Re: Objection to MP08_0244 MOD 1 Modification Request for Mixed Used Development at 23-37 Lindfield Avenue and 11 Havilah Lane, Lindfield

As a resident of Lindfield, I/we wish to lodge an objection against the proposed Modification of the subject development based on the following grounds:

1 SHADOW DIAGRAM - 21stDEC_9AM
5003 SCALE1 : 650

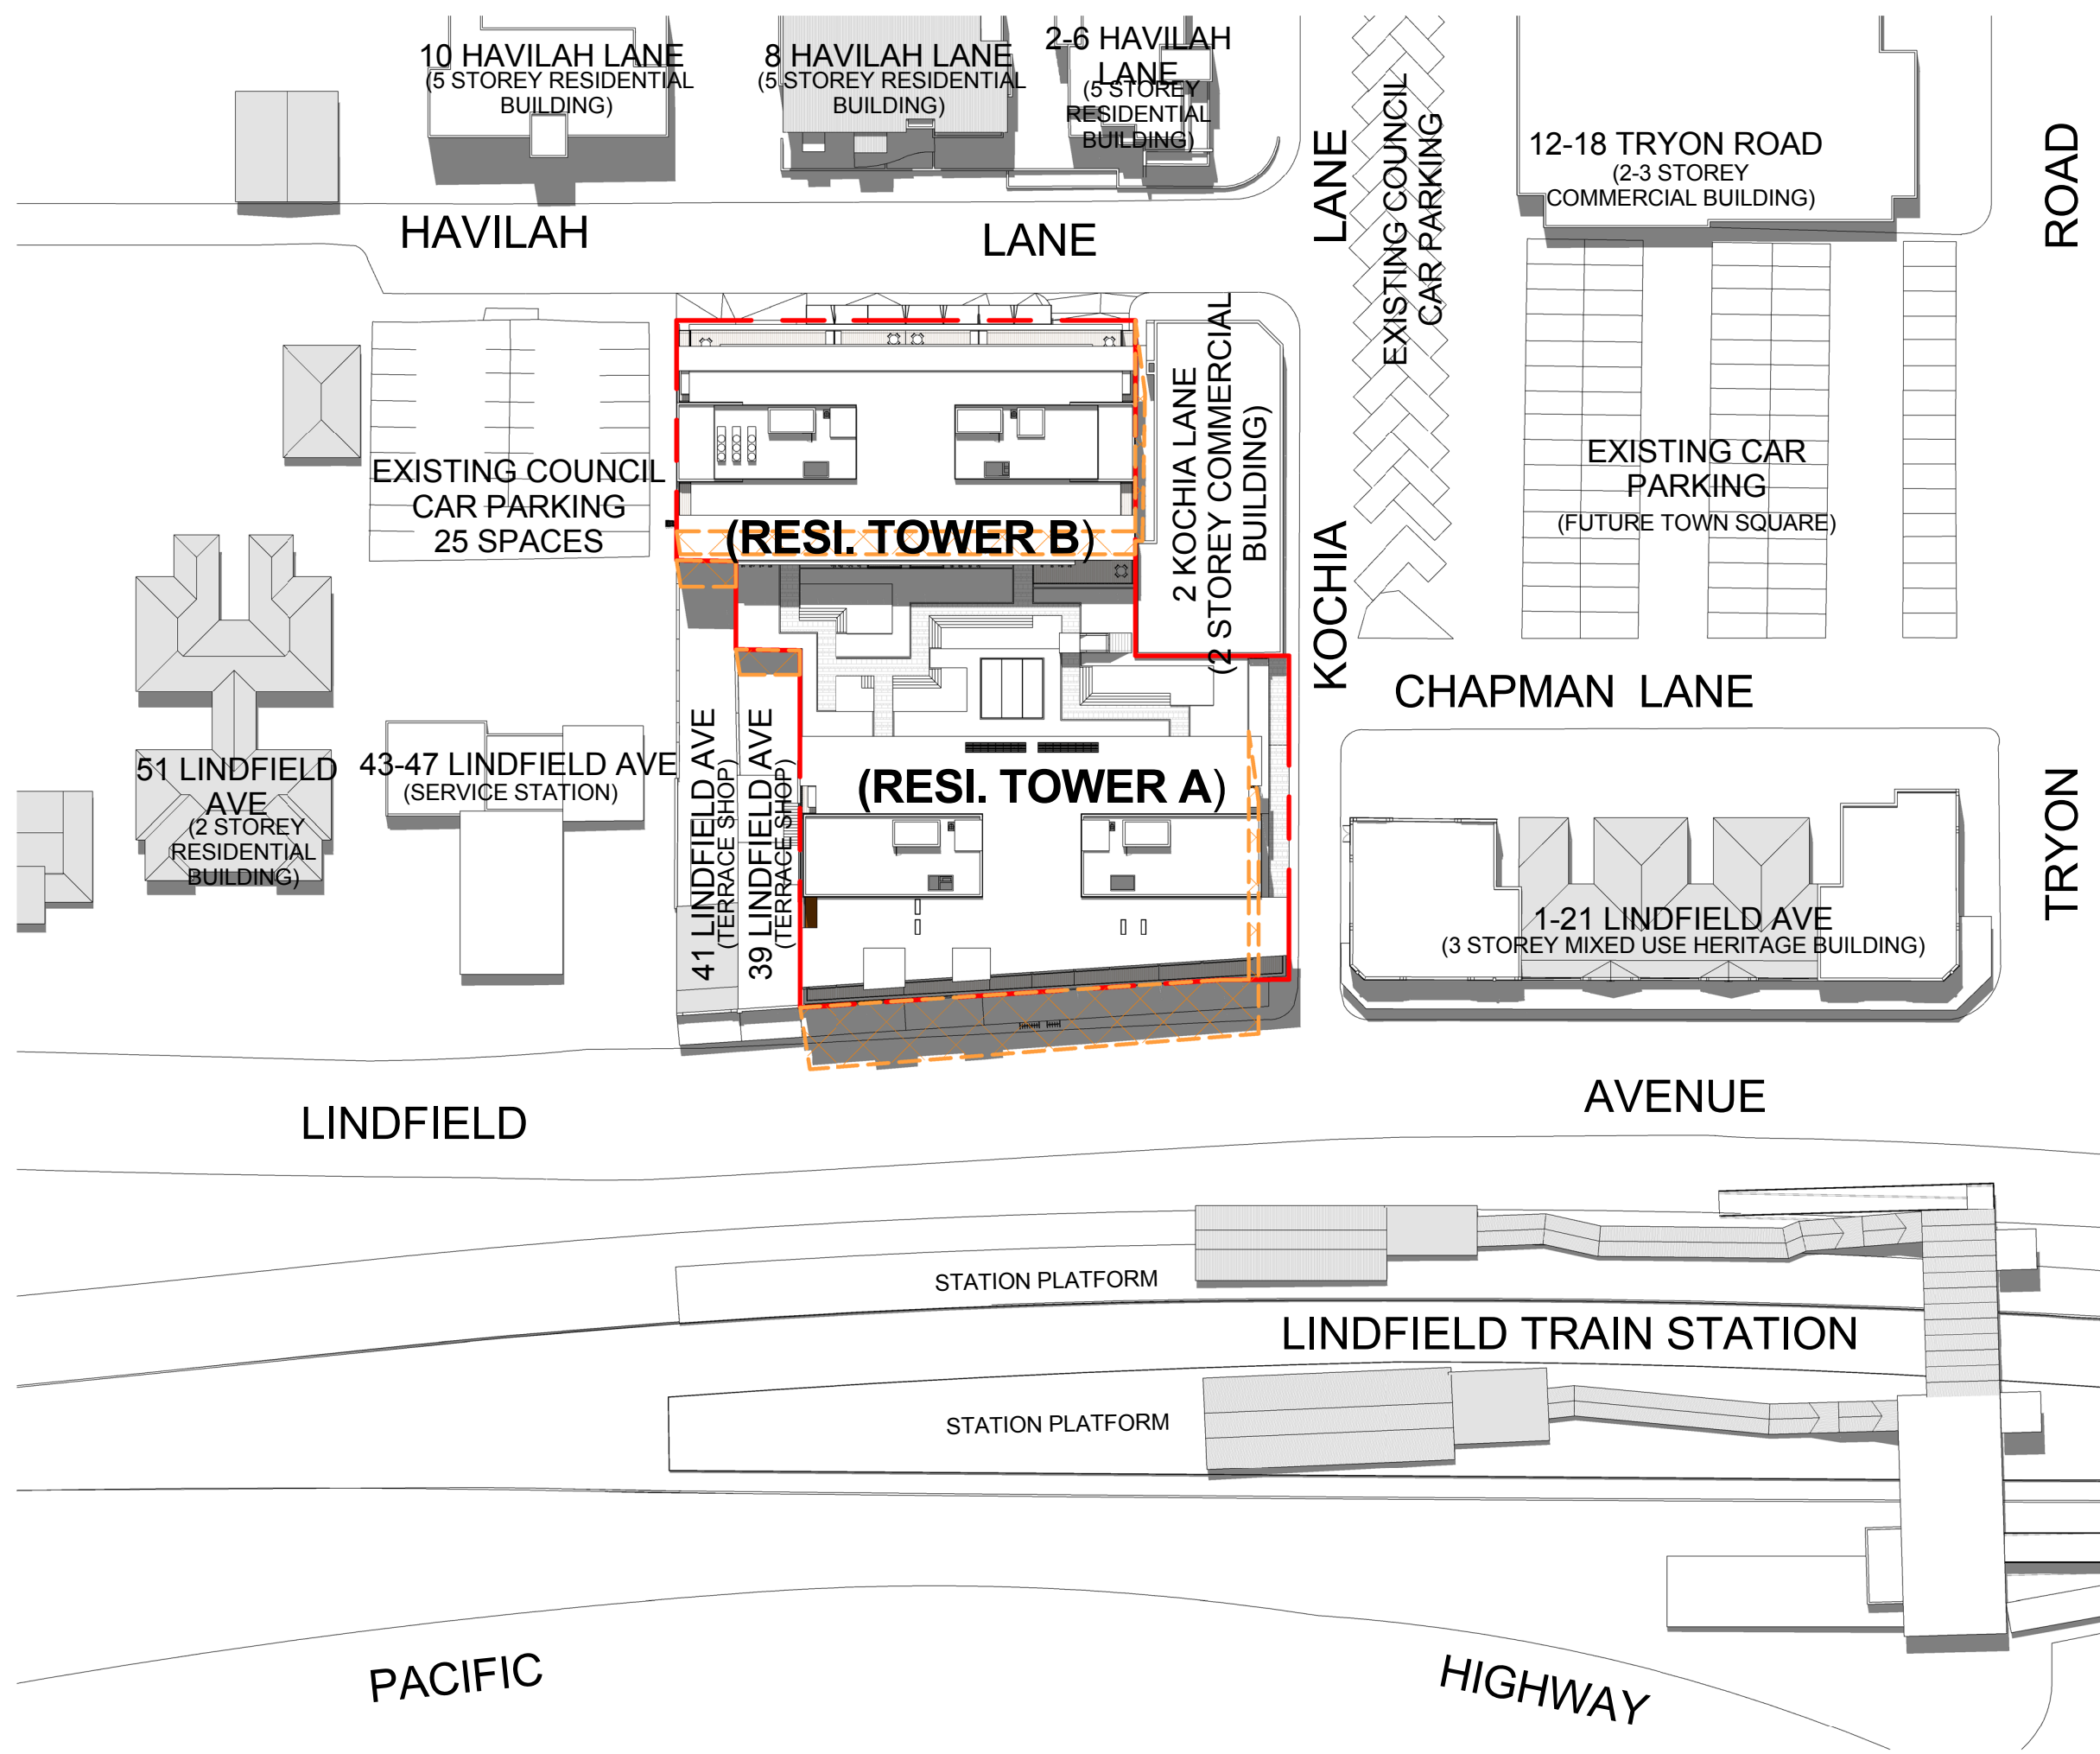
- The additional storeys create new adverse shadowing: a) for residents in the Havilah Lane apartments, particularly after 3pm b) for the popular outdoor café and central Lindfield hub area at 12 Tryon Road in afternoons, particularly in winter and c) for all commuters on the city bound Lindfield rail platform, instead of 50% of the year as approved, it will now be in shadow in the mornings 75% of the year

FIGURE 1.3 – MODIFIED SCHEME CAR PARKING

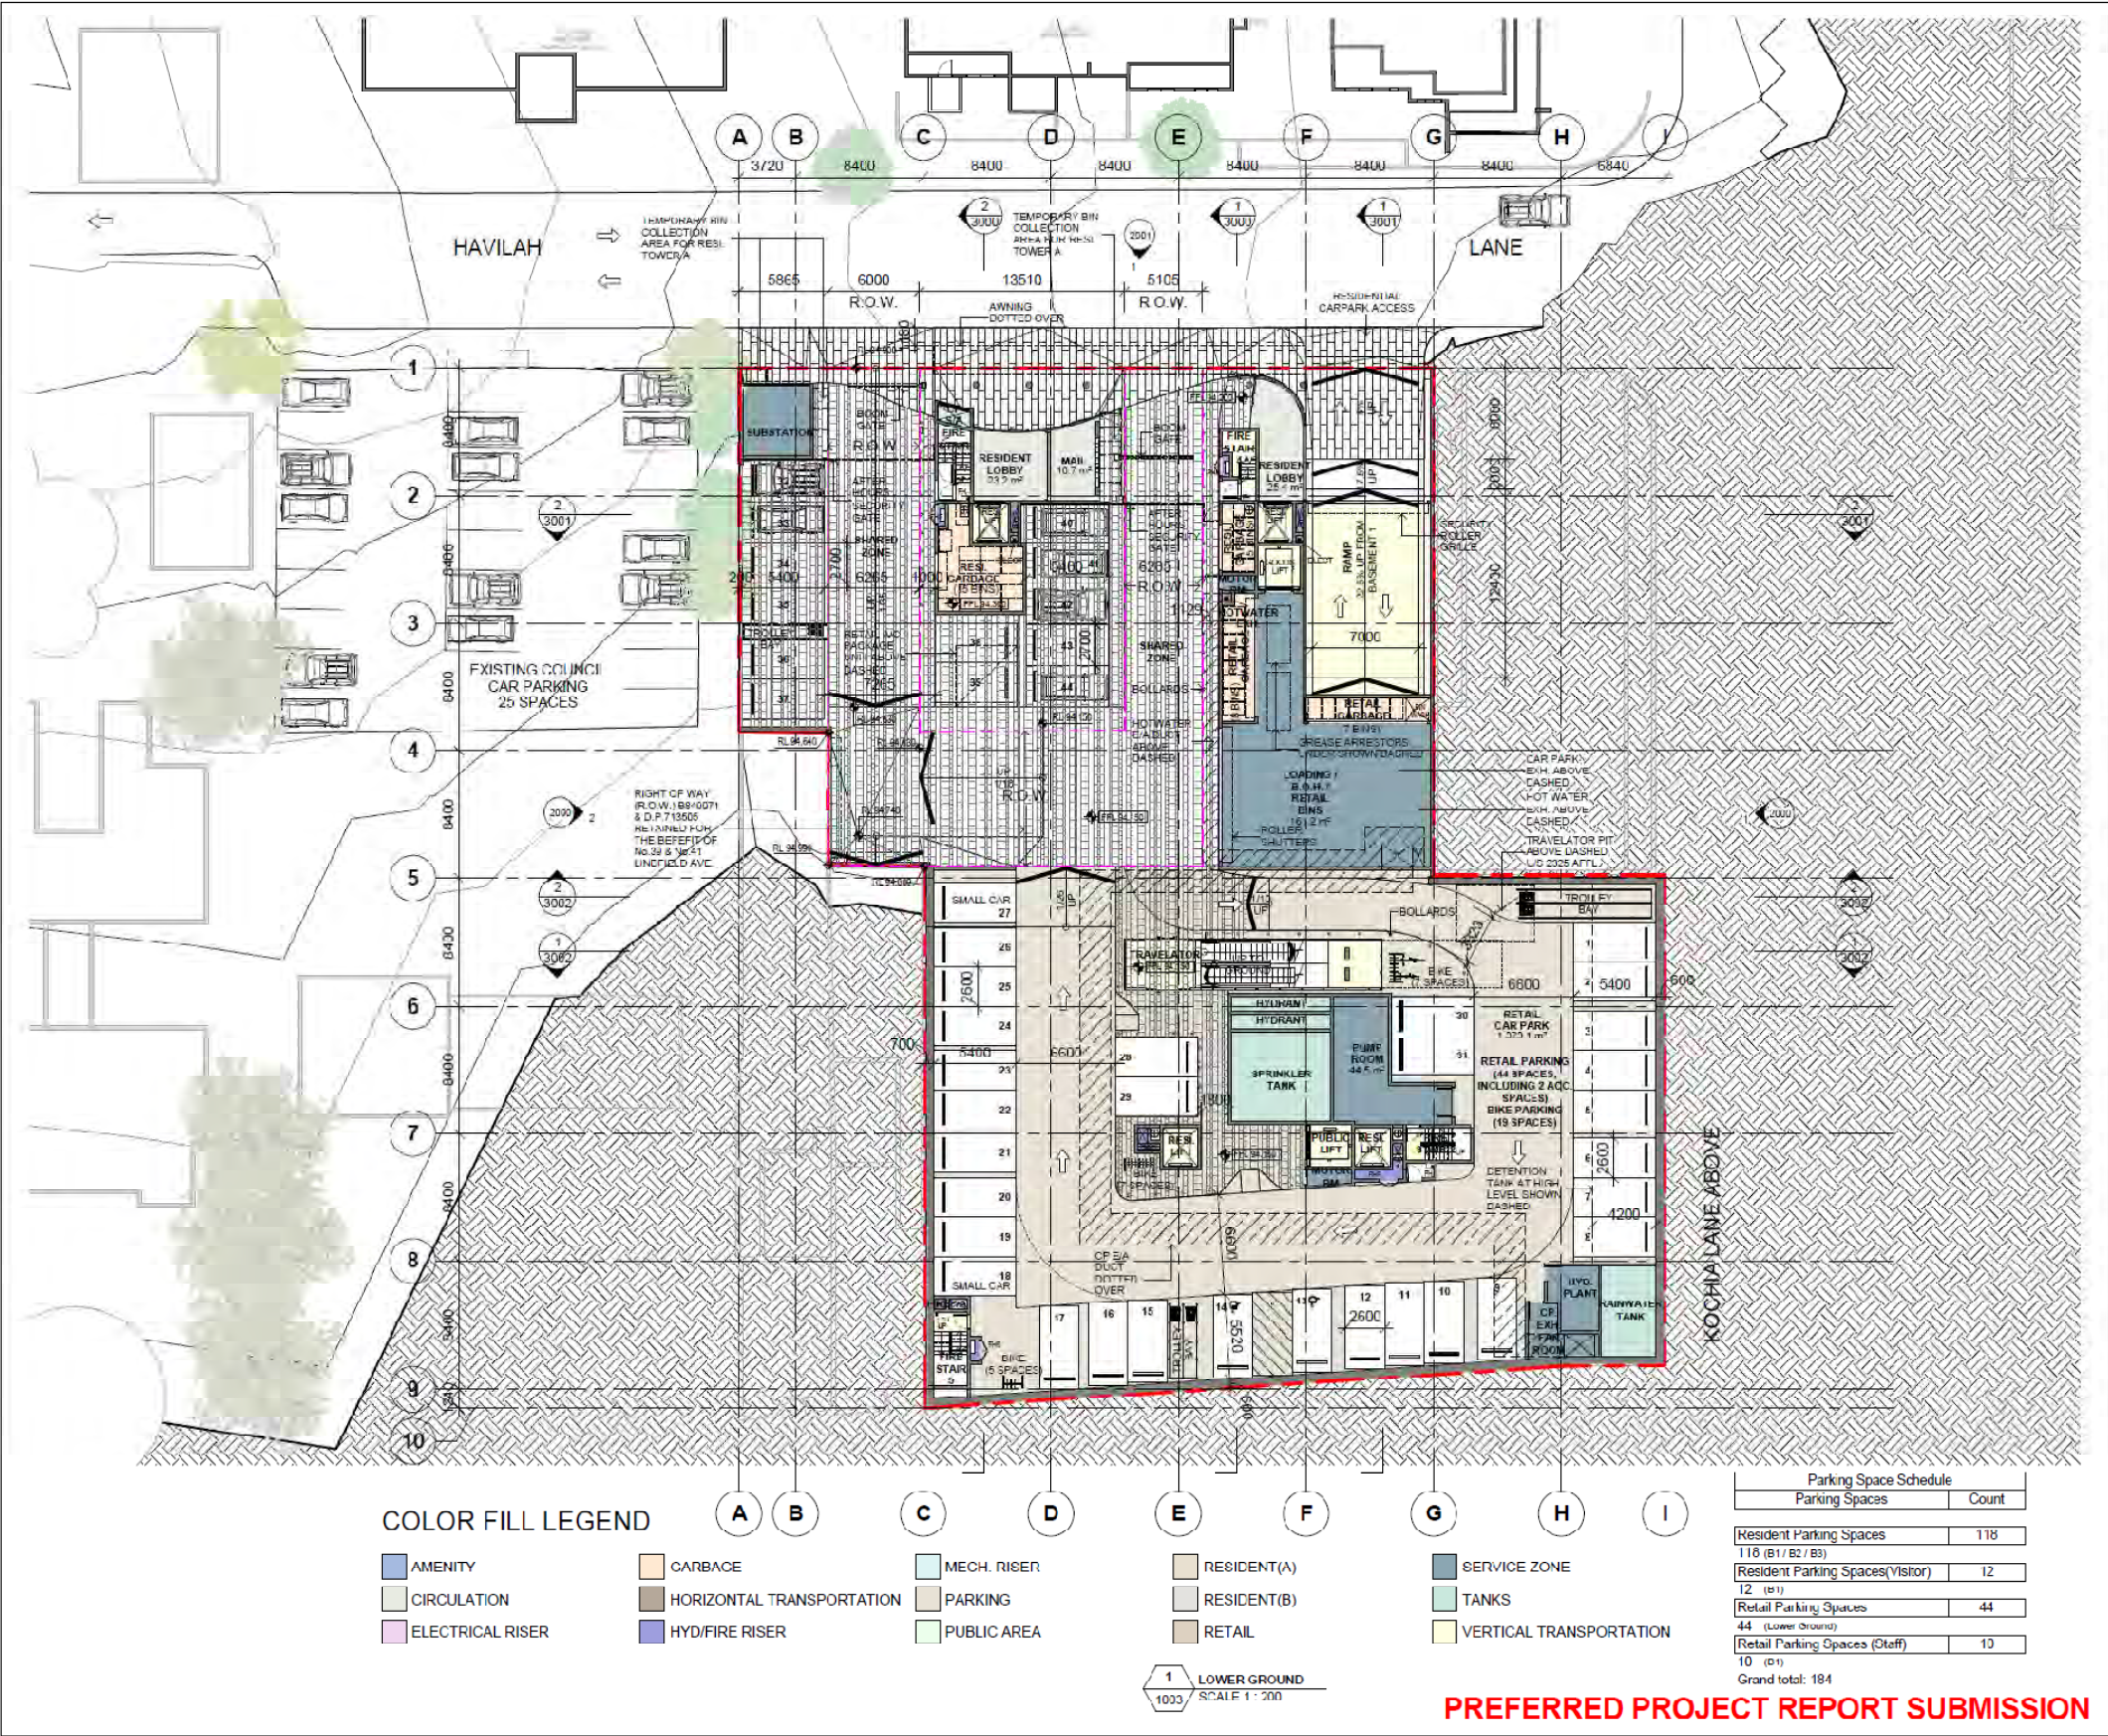
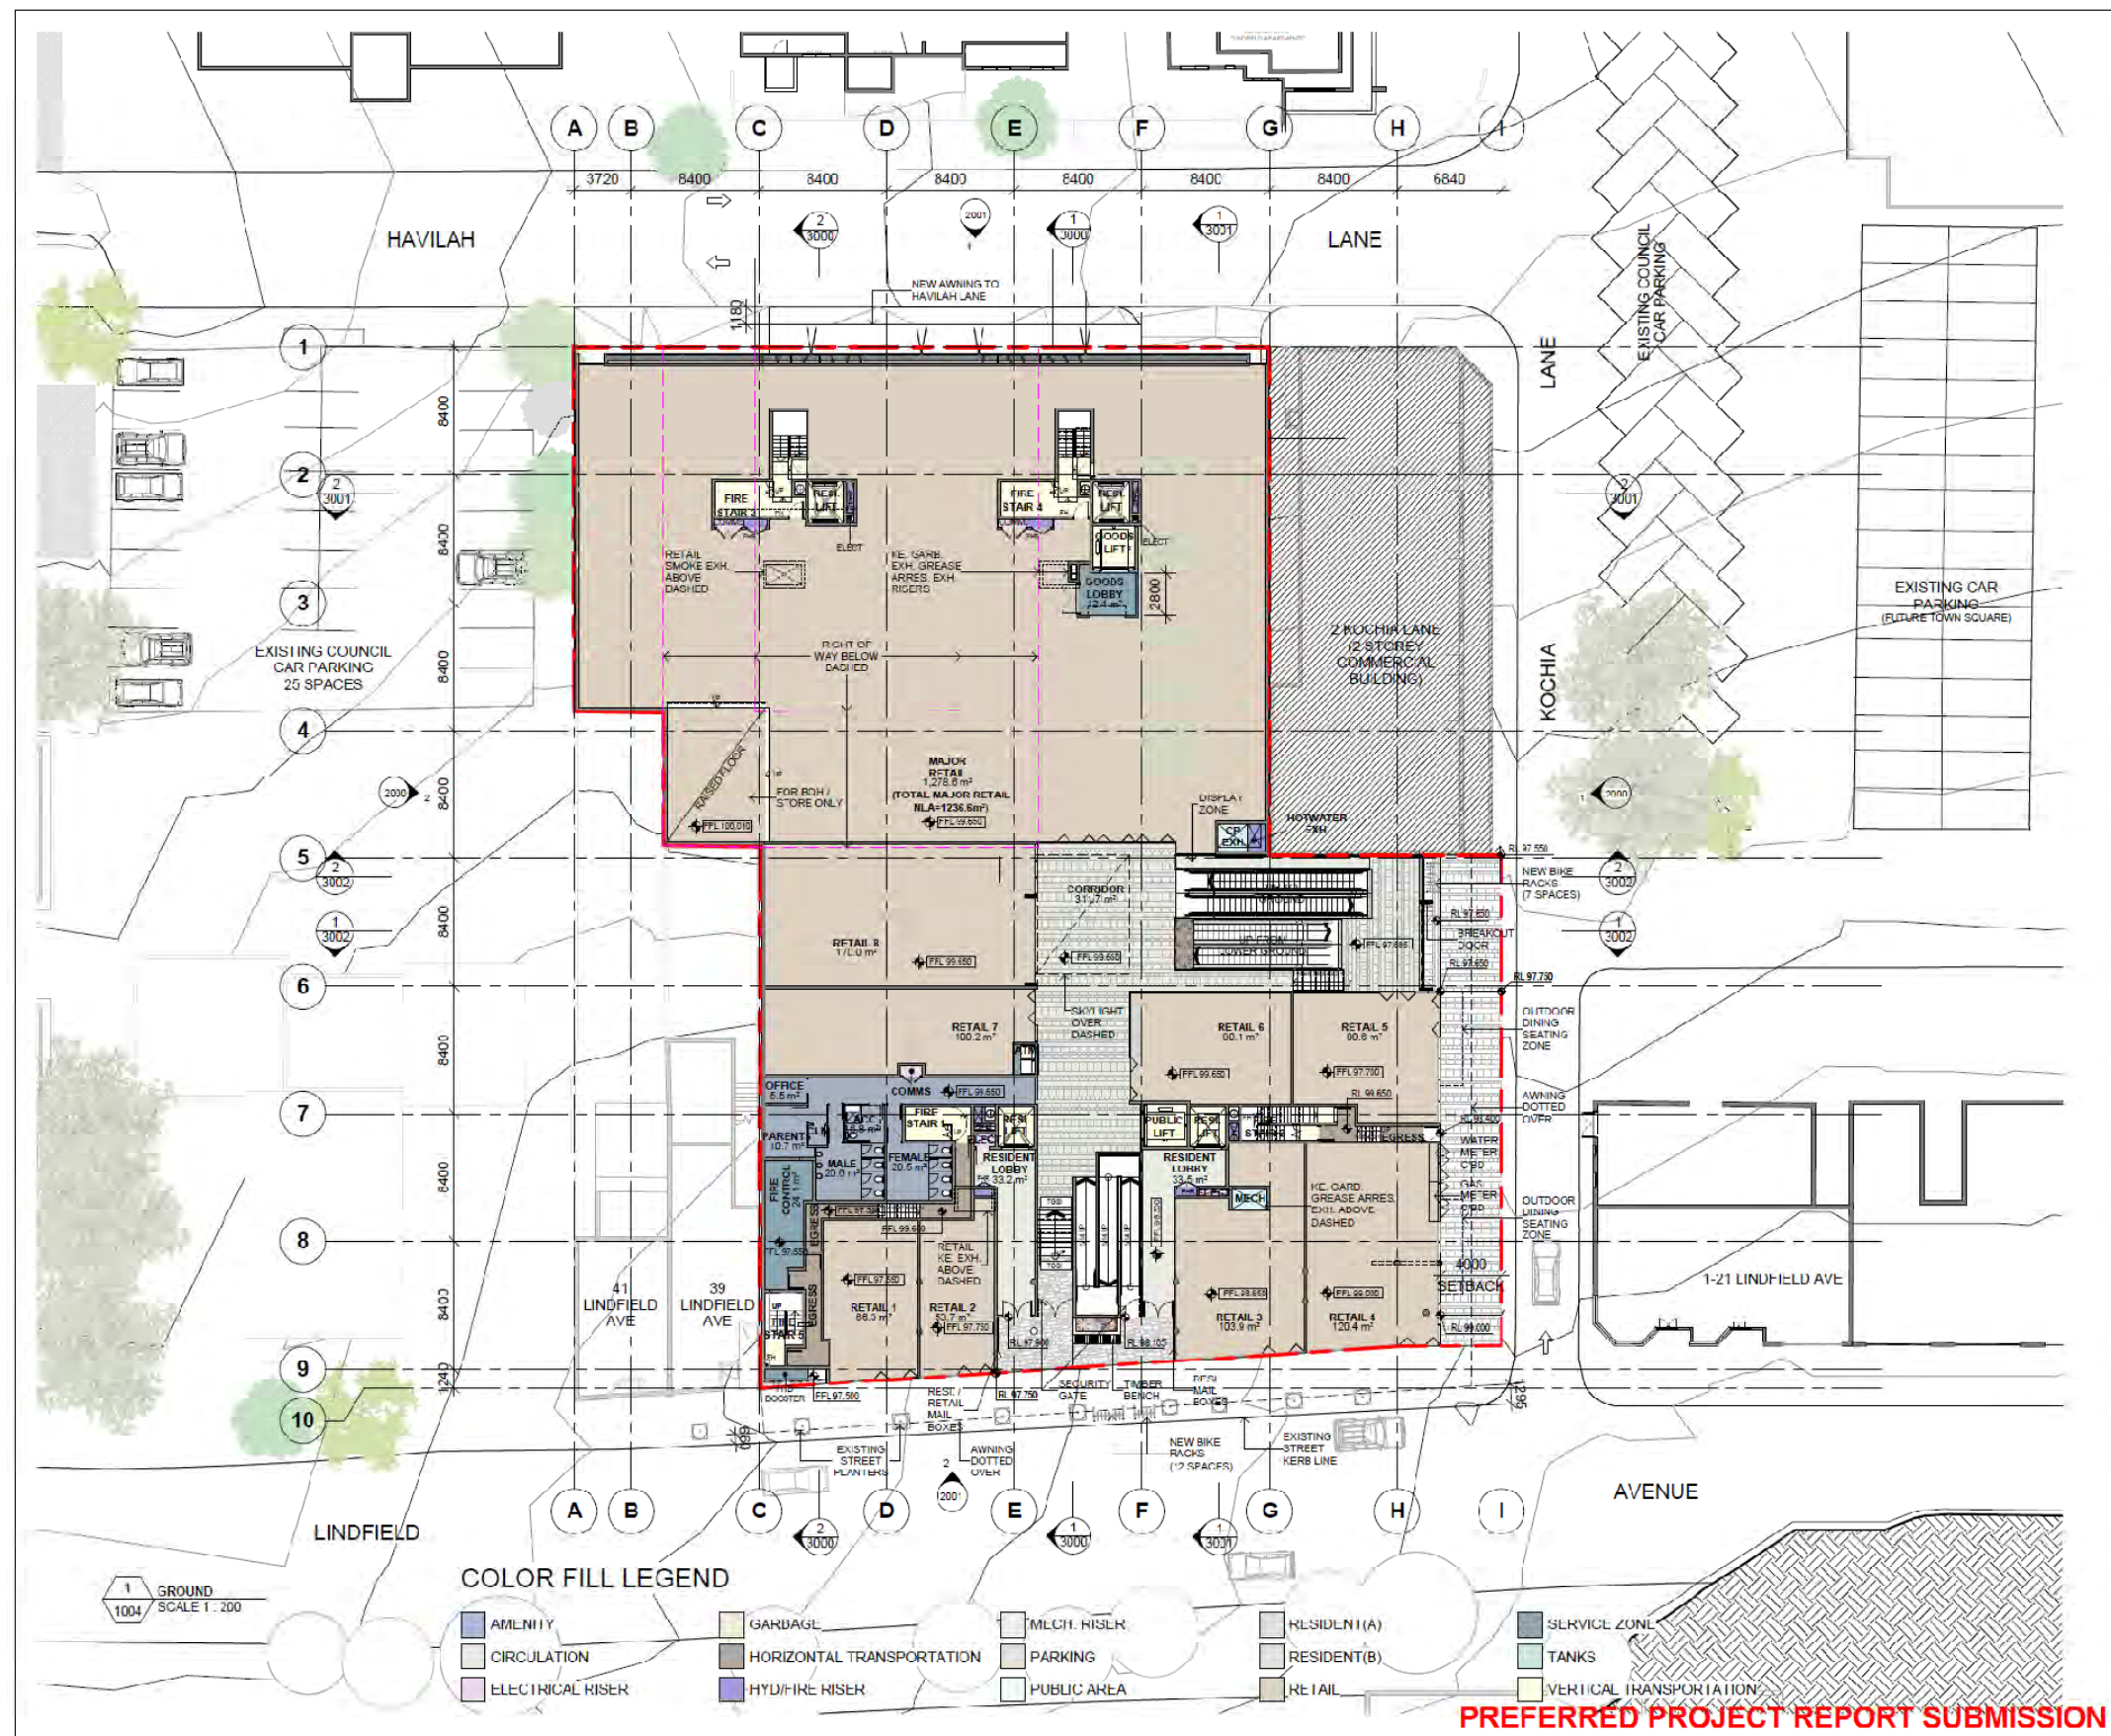
- Car spaces were identified as inadequate for the retail component and this has not been addressed relative to the remaining retail space proposed. The 25 car spaces counted as part of council's car park are also now highly uncertain due to the proposed rezoning and potential redevelopment.
